**RE: North Bay at Lake Woodmoor, PUD Development Plan (PUDSP-16-004) 1<sup>st</sup> Review Response**

This letter responds to your January 4, 2017 review letter relating to the above referenced project. Responses to review comments are shown in **RED** below.

**FLOODPLAIN AND  
FLOODWAY  
EXHIBIT**

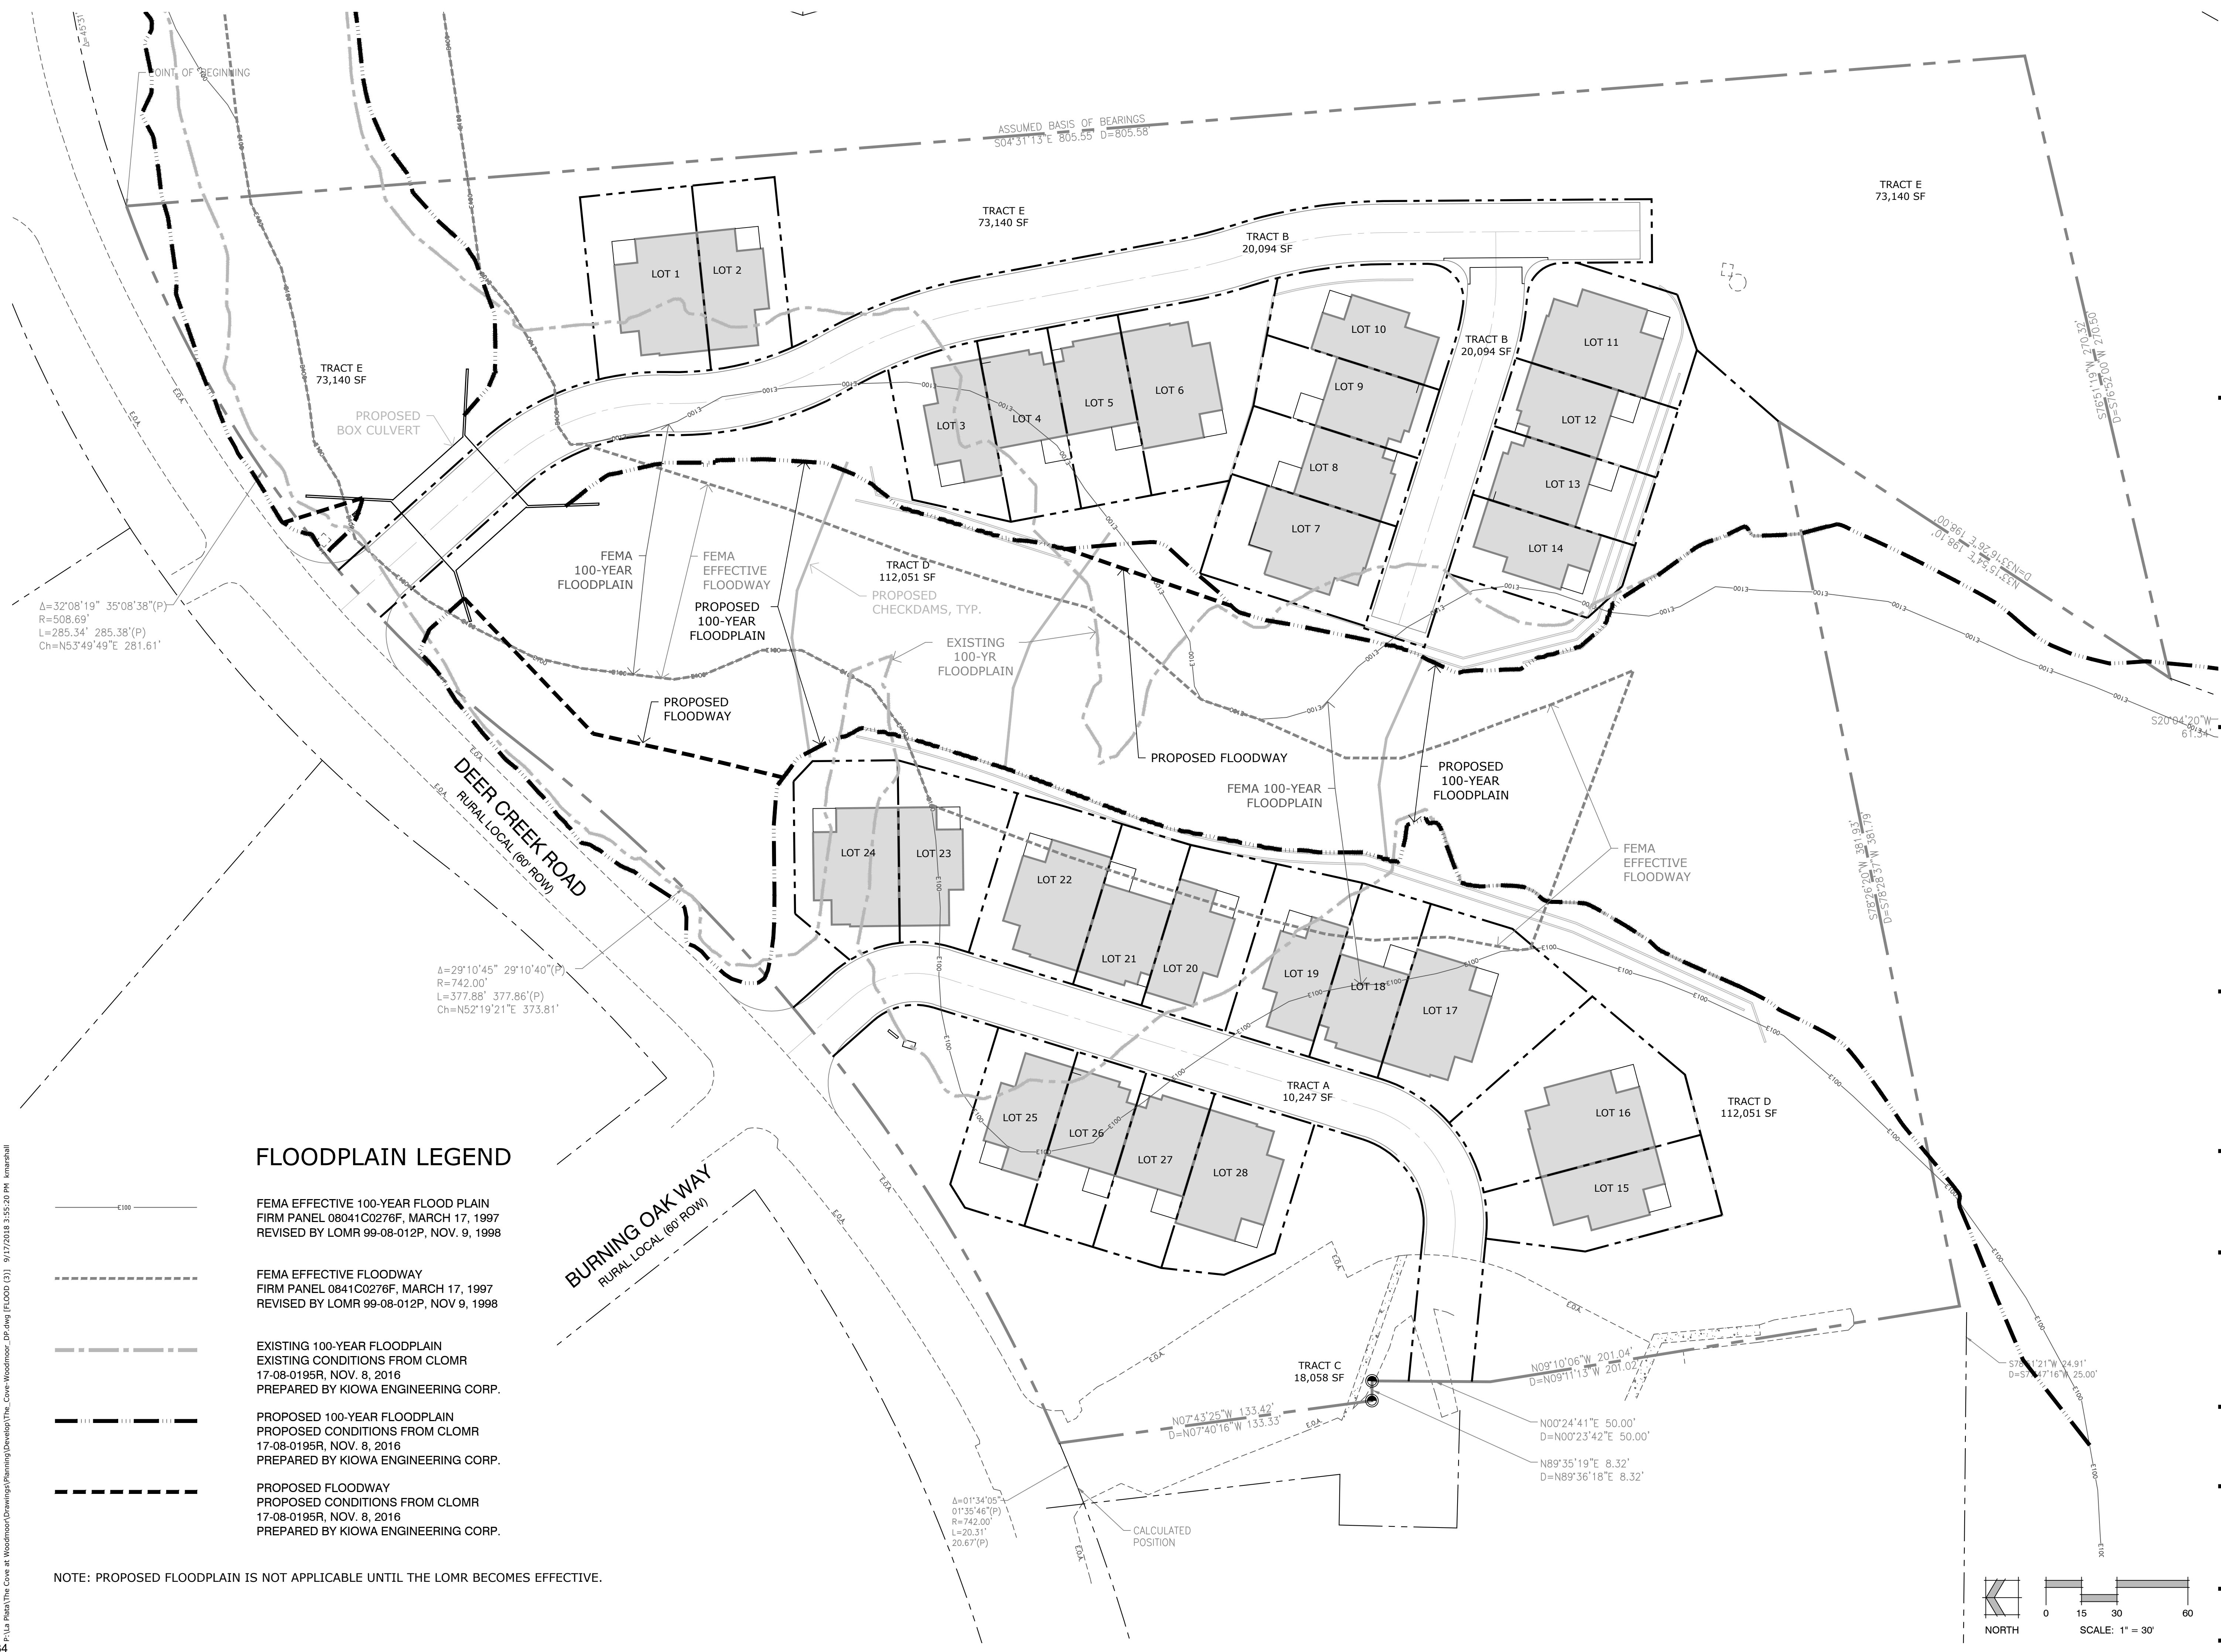
5. The floodplain as it exists and as intended to be amended should be depicted on the plan. Due to legibility concerns a separate sheet is encouraged. **Exhibit provided.**

1. Show/label the existing FEMA floodplain and floodway. **Provided on a separate sheet.**
2. Add a note stating the proposed floodway is not applicable until the LOMR becomes effective. **Added.**
